From: Olivia Hughes <OHughes@offalycoco.ie>
Sent: Tuesday, August 8, 2023 12:31 PM
To: Bord <bord@pleanala.ie>
Cc: Edward Kelly <ekelly@offalycoco.ie>; Carroll Melia <cmelia@offalycoco.ie>
Subject: ABP-317562-23 DEC 23/15

Please see below Offaly County Council's submission in relation to ABP-317562-23 :-

EXISTING SITE ENTRANCE

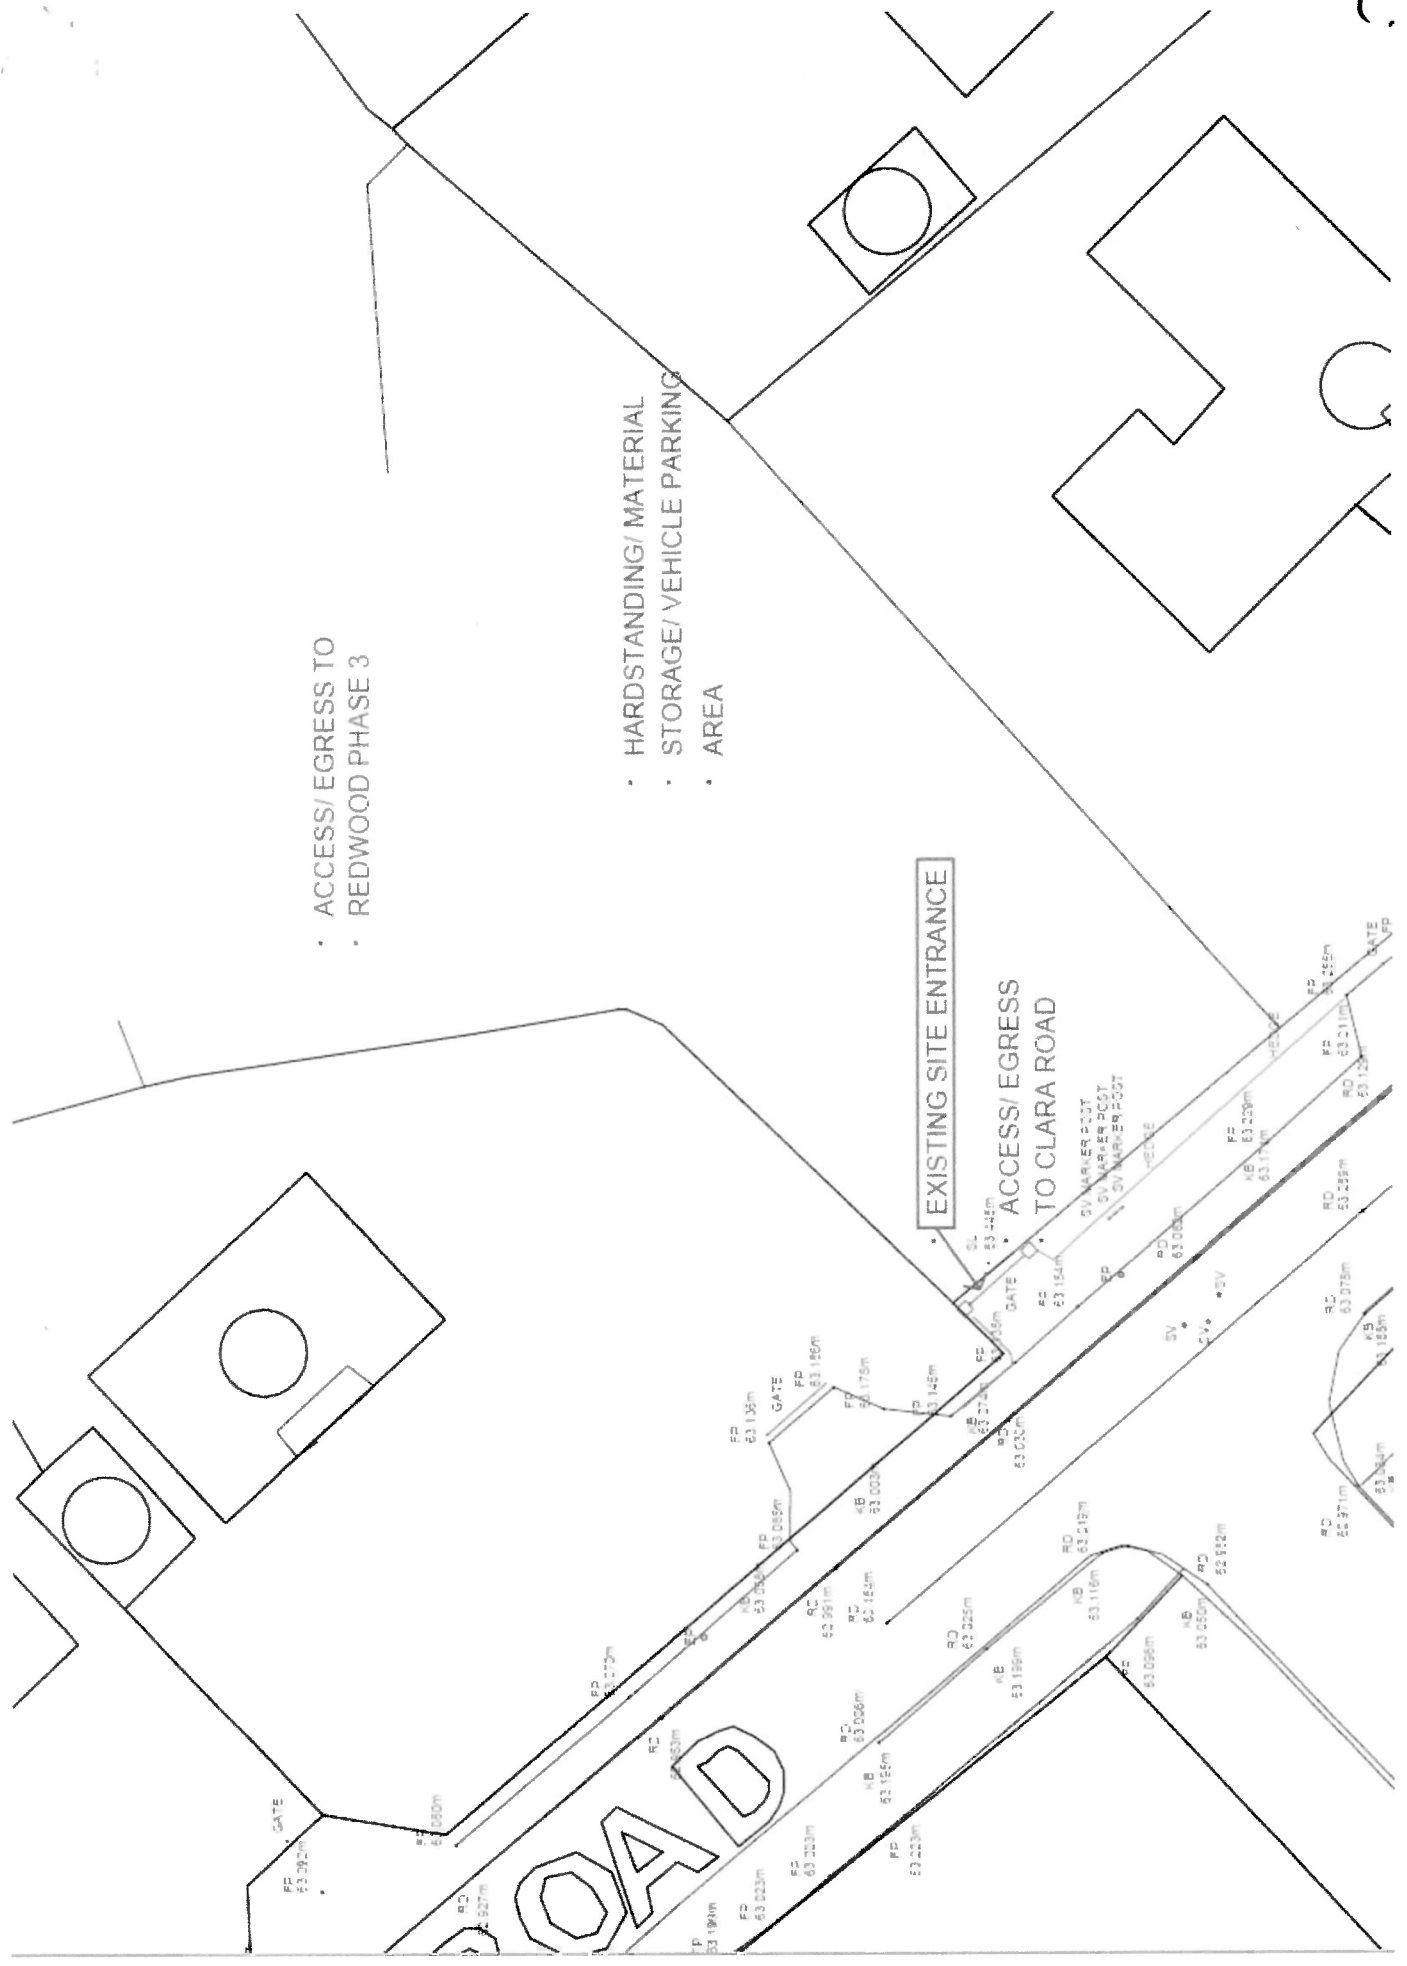
Offaly County Council notes that an entrance pier and gates have been removed from the entrance which has therefore resulted in the significant modification of the entrance. Please see OCC section 5 report photos for details. The entrance may have been extended to allow construction traffic to enter the site.

Offaly county Council considers that the widening of the entrance on site are ancillary works to the development subject of this declaration and cannot reasonably be considered in isolation from these works, particularly having regard to the resurfacing of the entrance route which forms part of the application for a declaration.

The applicants production of a traffic management plan indicates that a material change of use of the entrance has taken place.

The relevant SEE has indicated that the entrance is a hazard. Please see email on file.
